21st February 2024

Application Reference: 6/2022/1106/FULL

Proposal: Erection of 1 x detached 4 bedroom dwelling and detached 3 storey building accommodating 6 x 2 bedroom flats, car parking, refuse and recycling bins enclosure, secure cycle storage, turning heads and use of the existing vehicular access following the demolition and removal of a pair of semi-detached dwellings

Location: 1 Longcroft Green, Welwyn Garden City, AL8 6EP

**Apartment Block
Proposed Layout Plans
Ground & First Floor**

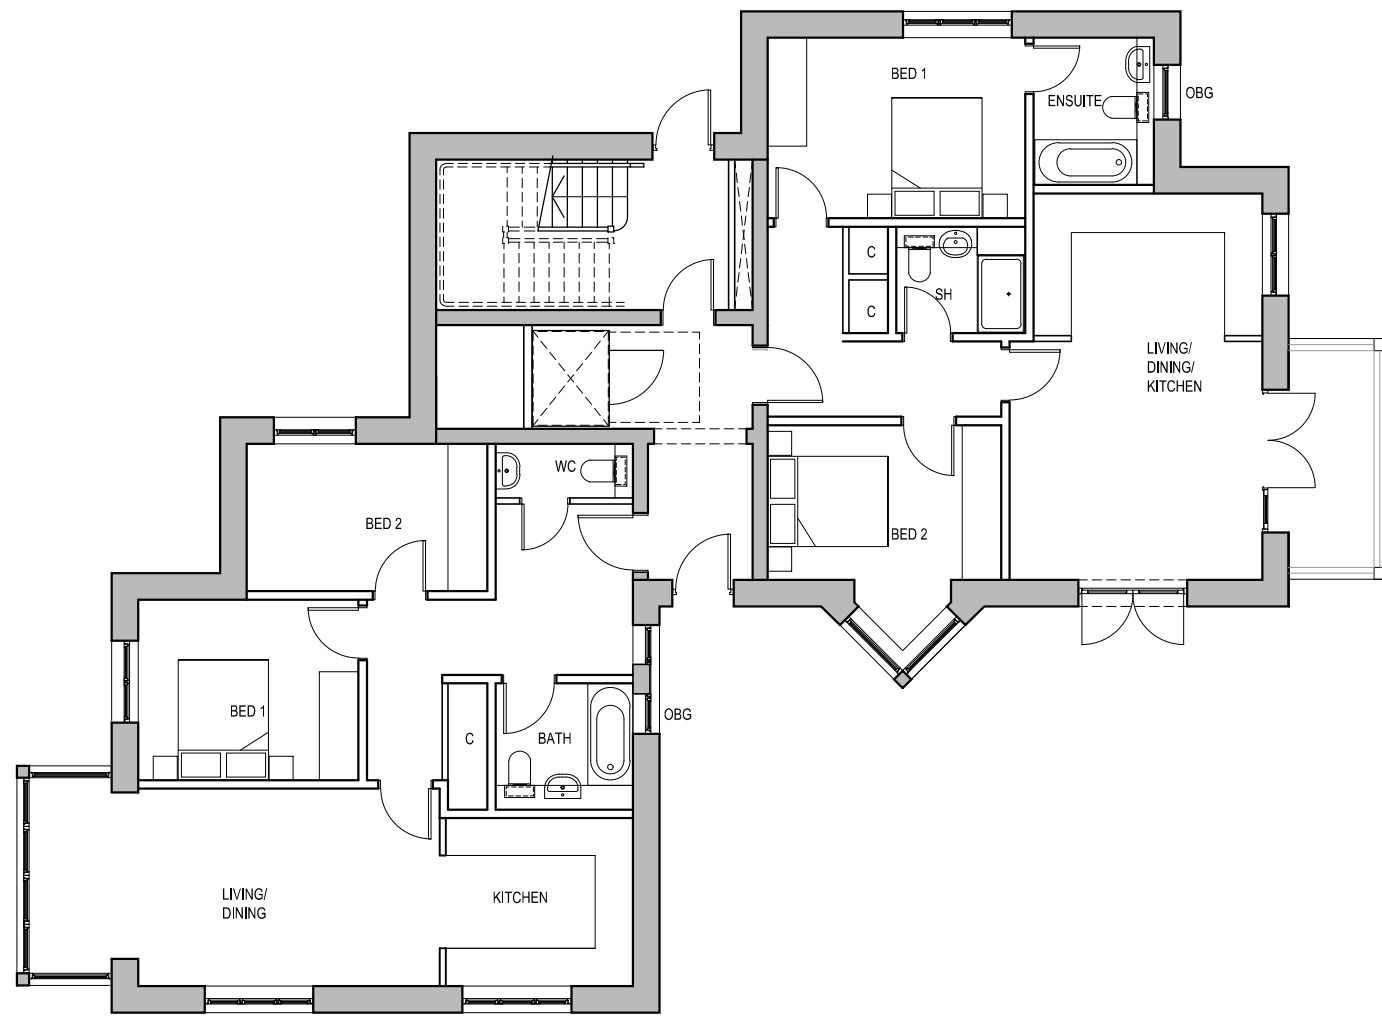
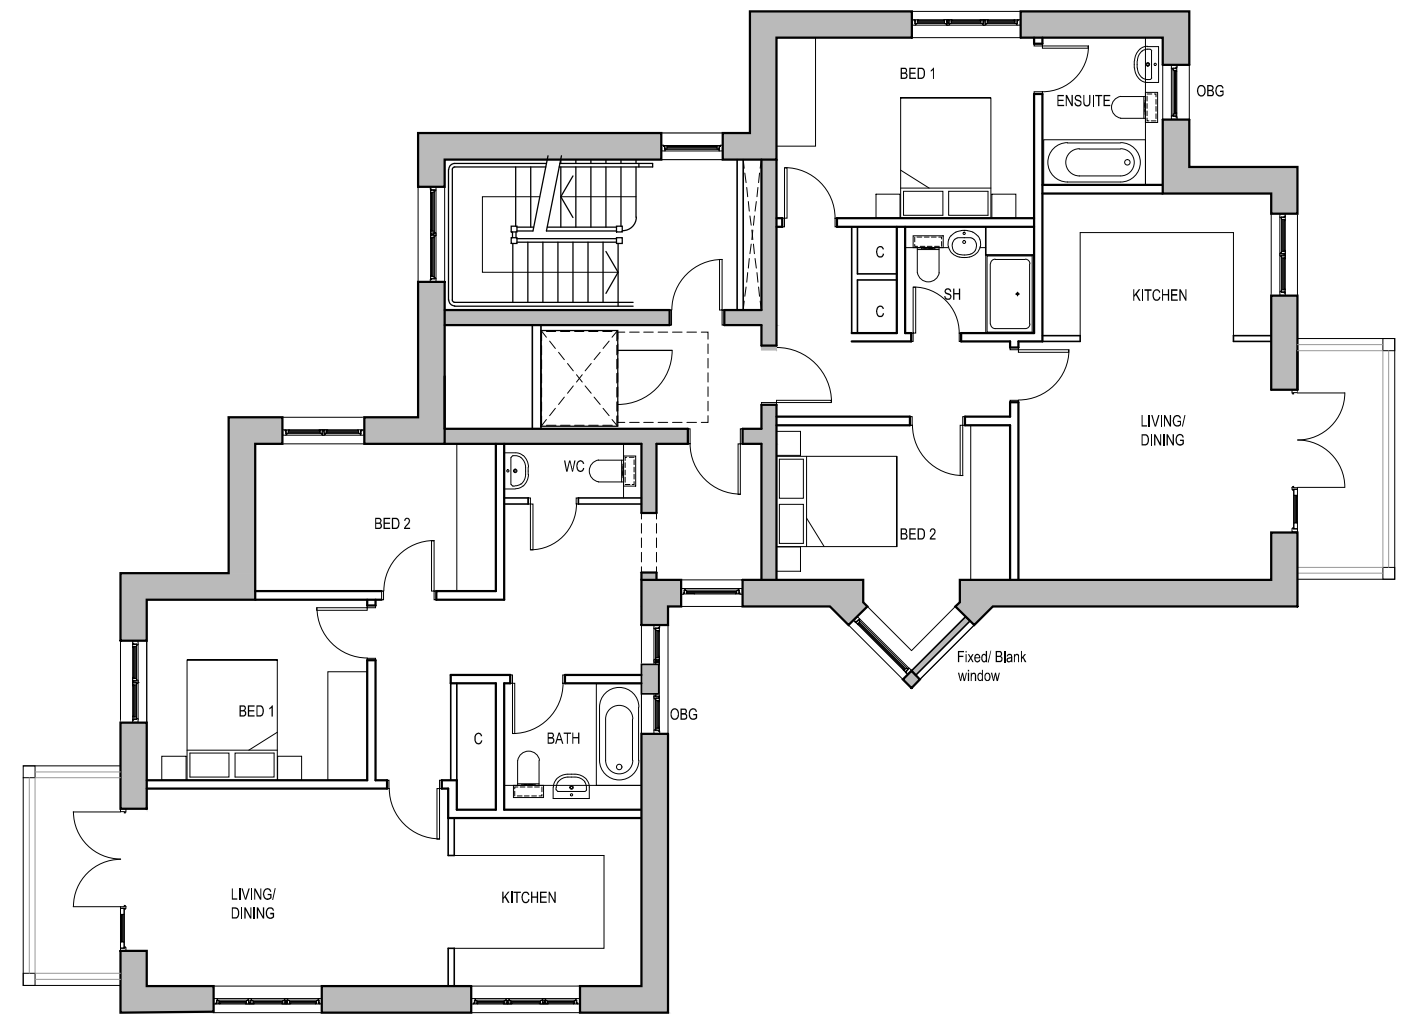
A considerable amount of attention was originally given to the design of the flats to ensure that the windows and balconies did not materially affect the privacy of No 3 Longcroft Green and this matter was addressed in our letter dated 27th June 2022 providing a detailed response to comments made by neighbours at 3 and 4 Longcroft Green through the consultation process. This letter noted that the only windows in the block of flats offering views in to the garden of No. 3 are in halls and bathrooms were fixed and obscure.

The removal of the top storey duplex level can only improve this situation and Drawing 104 Rev B and 105 Rev B clearly identify the position of fixed obscure windows and privacy screens on balconies to the relevant flats.
